Rezoning Transportation Analysis

Petition Number: 2020-141

General Location Identifier: Tax ID 12708701

Date	Description
10-26-20	First Review
11-30-20	Second Review (WB)
12-28-20	Third Review (WB)

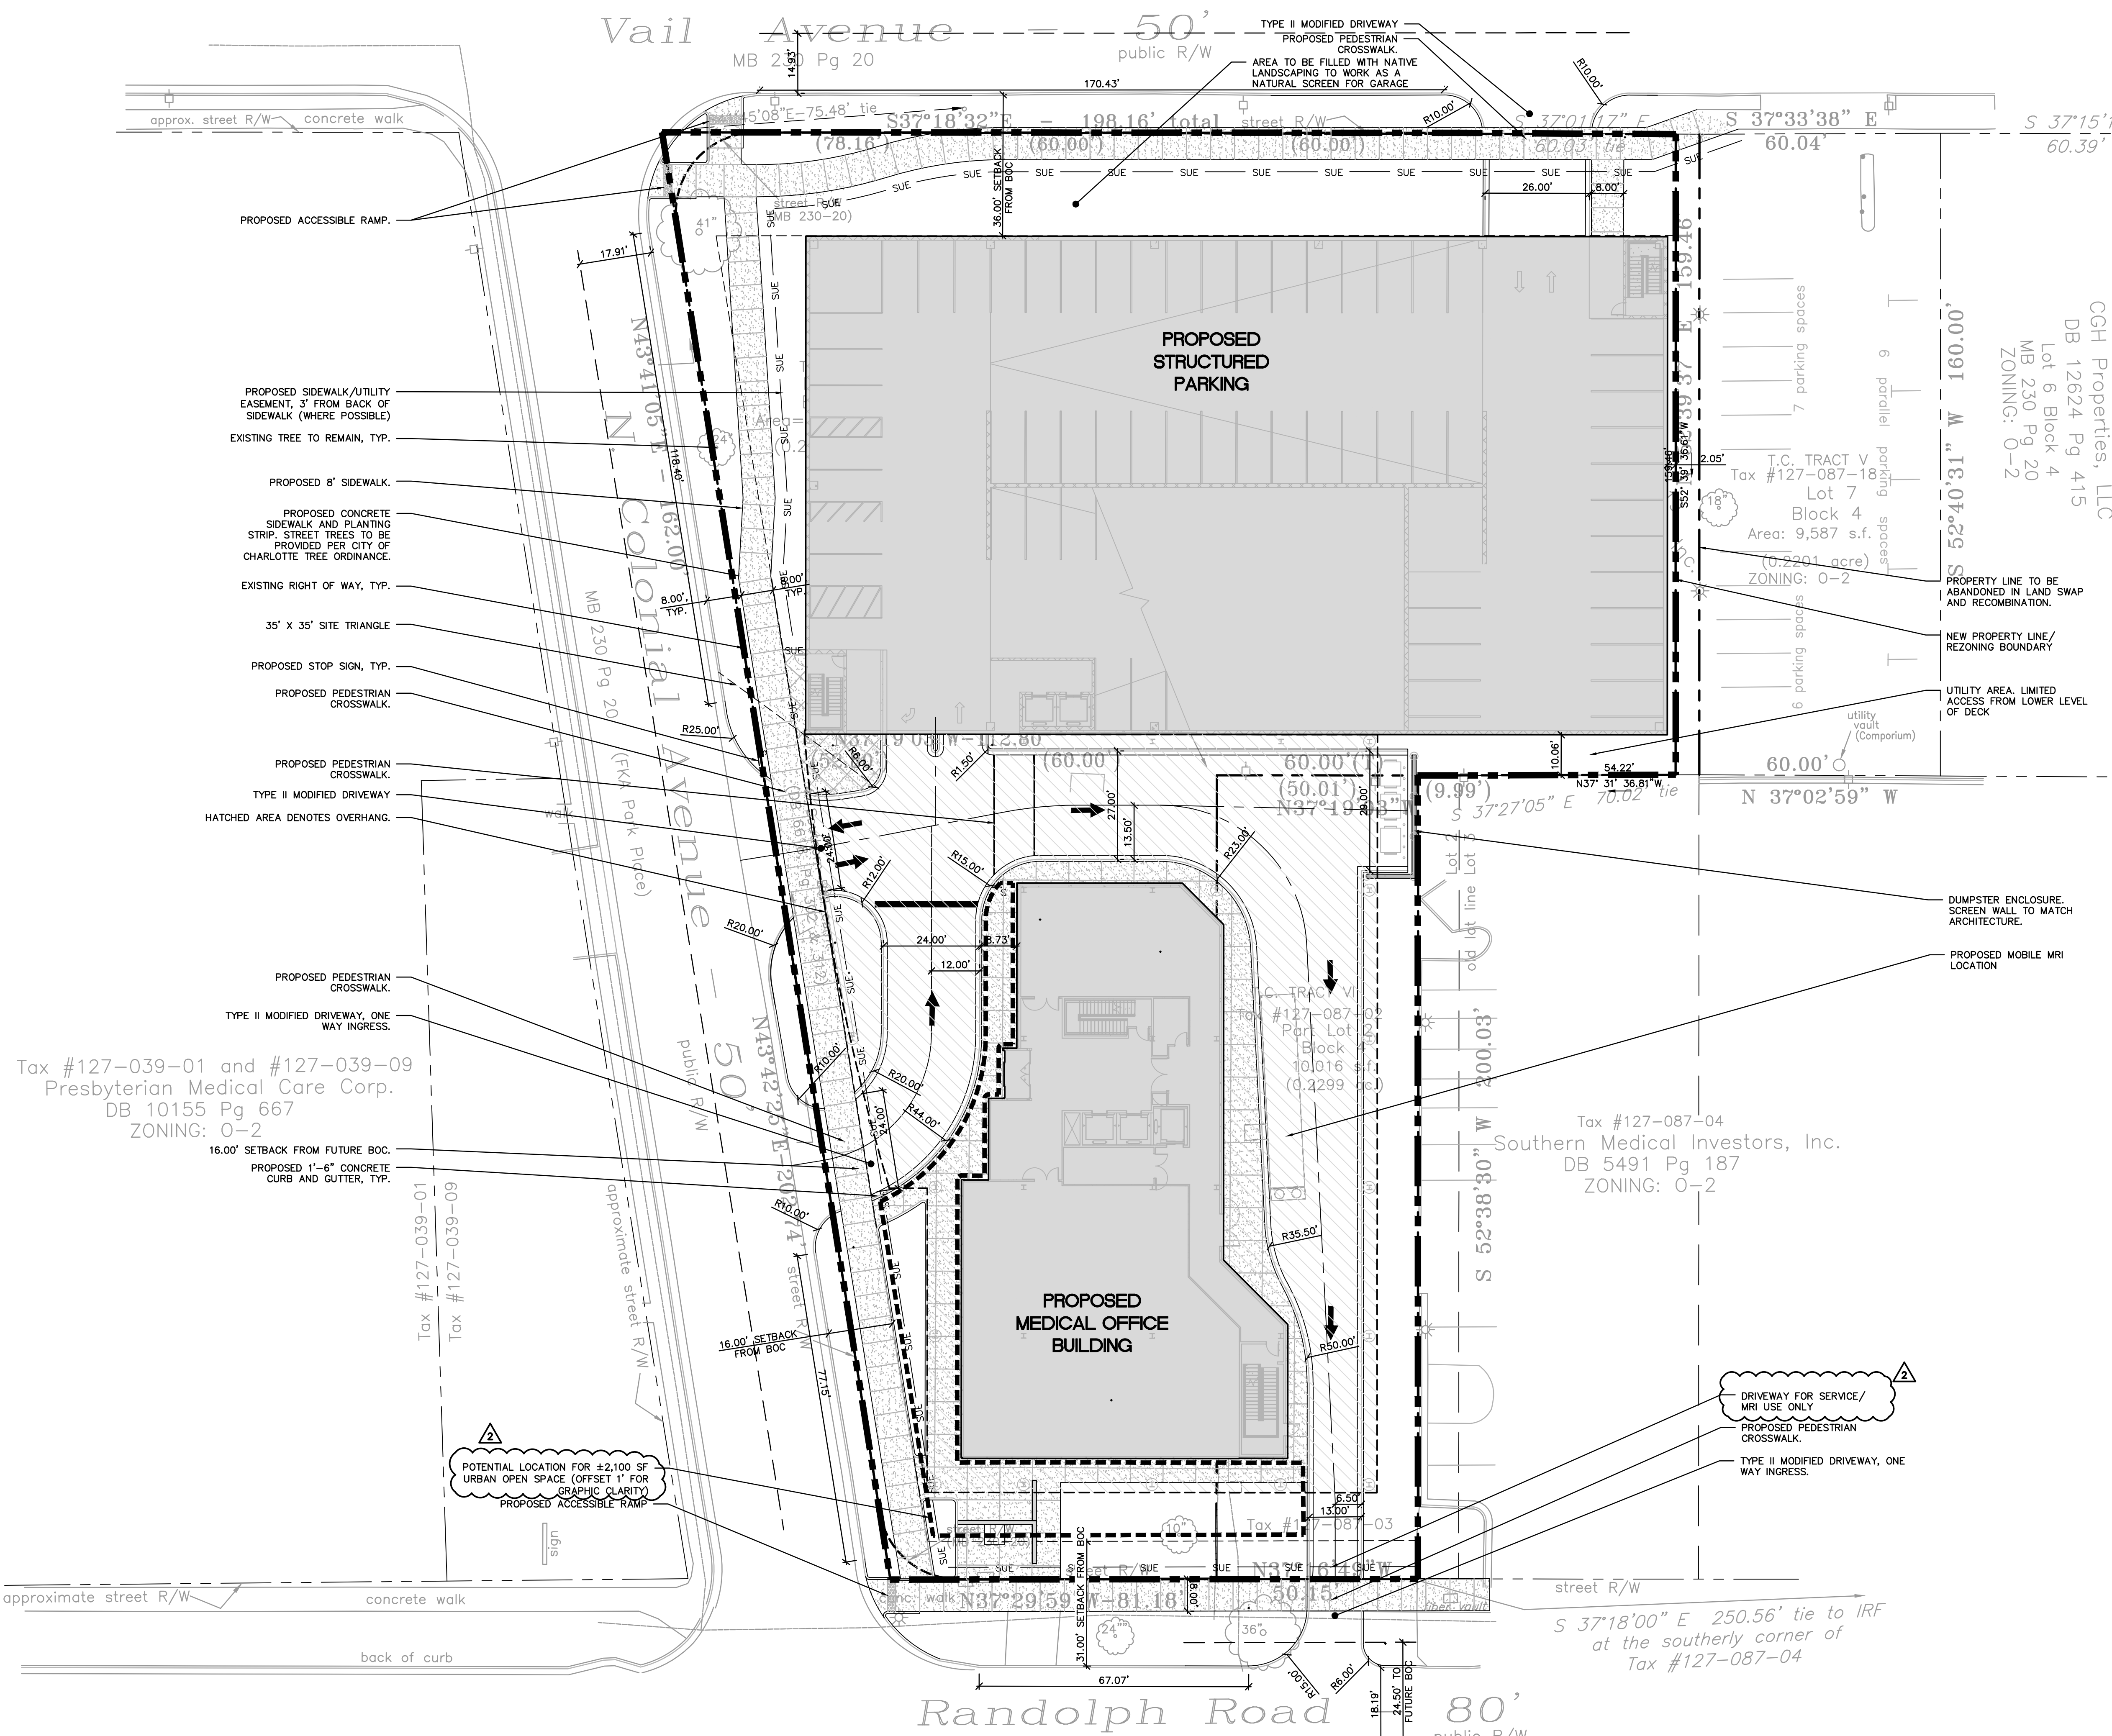
Label and dimension curb and gutter from the centerline for each road on the site plan.

3. ~~Revise site plan and conditional note(s) to commit to constructing an 8-foot planting strip, and 8-foot sidewalk along the site's frontage per Chapter 19. The wider sidewalk also meets the Charlotte WALKS Policy.~~

4. ~~Revise site plan and conditional note(s) to commit to constructing two ADA Curb ramps per intersection quadrant in accordance with the ADA law and PROWAG. The site plan shall label and dimension these items from the back of curb and gutter.~~
